Subject: RE: Application Ref. Y/48/19/DOC, Seeking the Discharge of Conditions 9 and 10 of Outline Consent Ref. Y/5/17/OUT - Land at the Former Cinders Nursery, Cinders Lane, Yapton, BN18 0JJ

Principal Planner, County Highways Team – Highways, Transport and Planning

Construction Method Statement

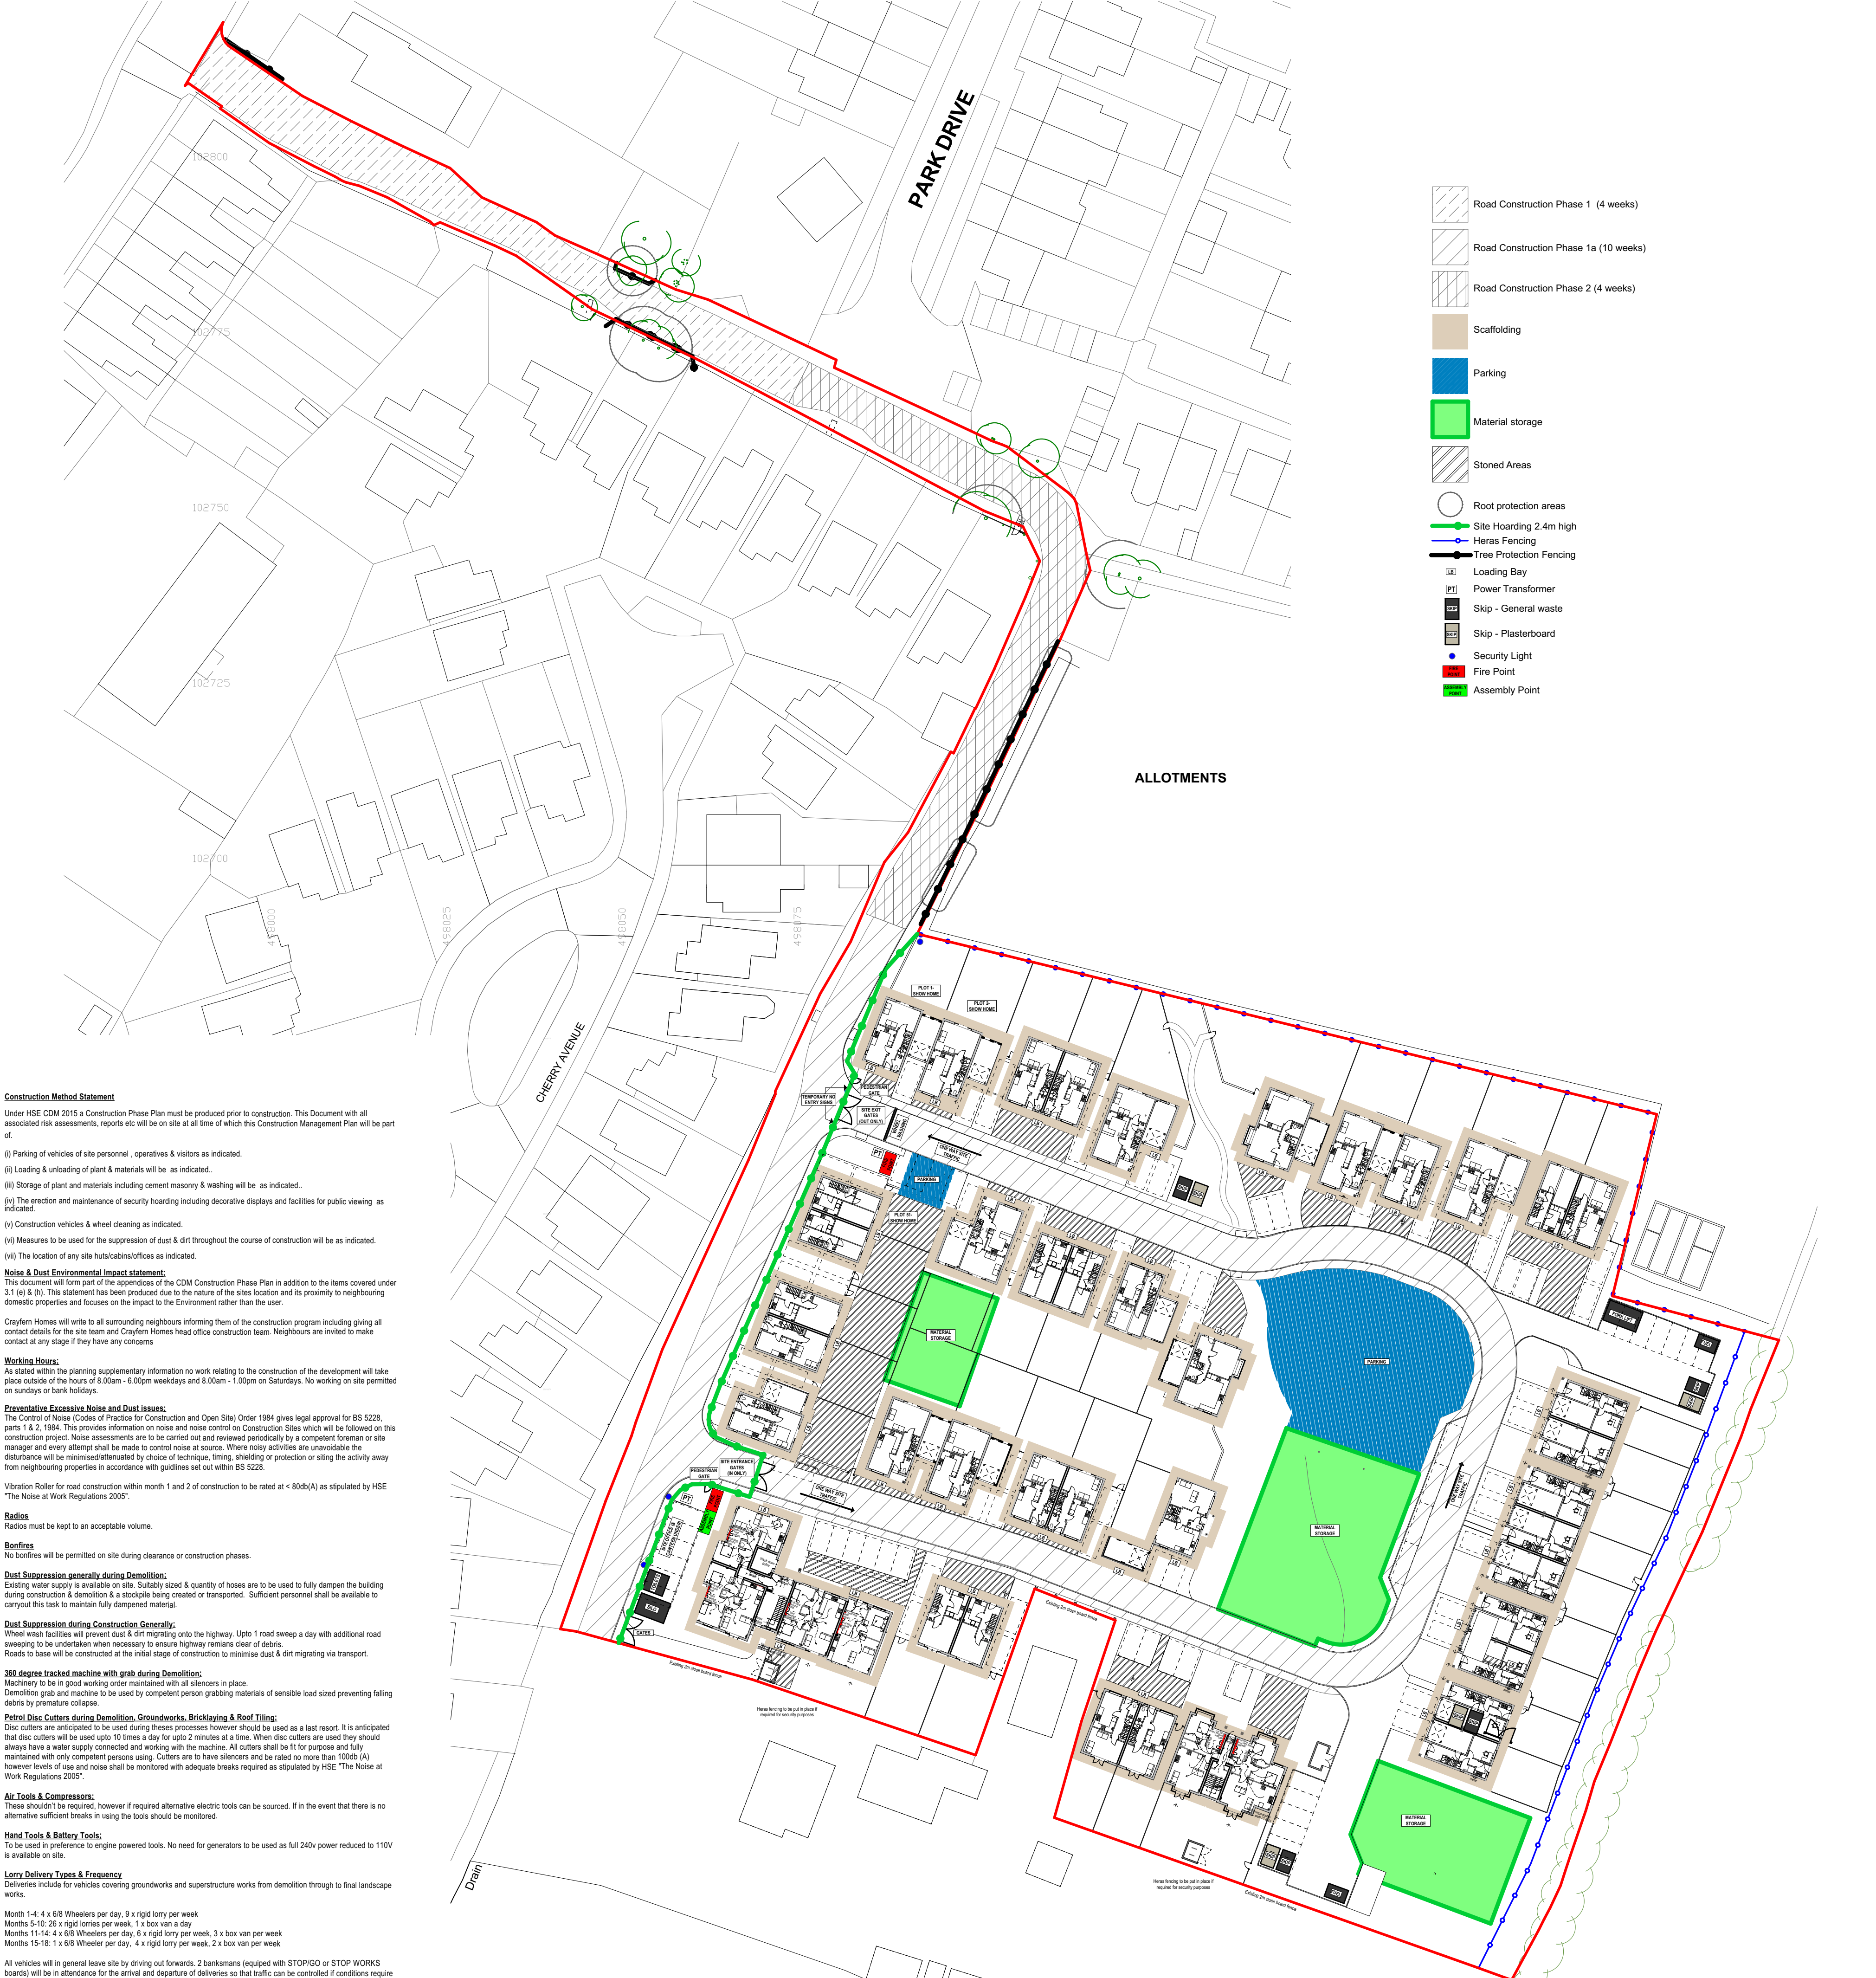
On a final point, I have noticed that no Heras (or similar) boundary fencing appears to run along the southern boundary of the site. Is there a reason for this or is it simply an omission?
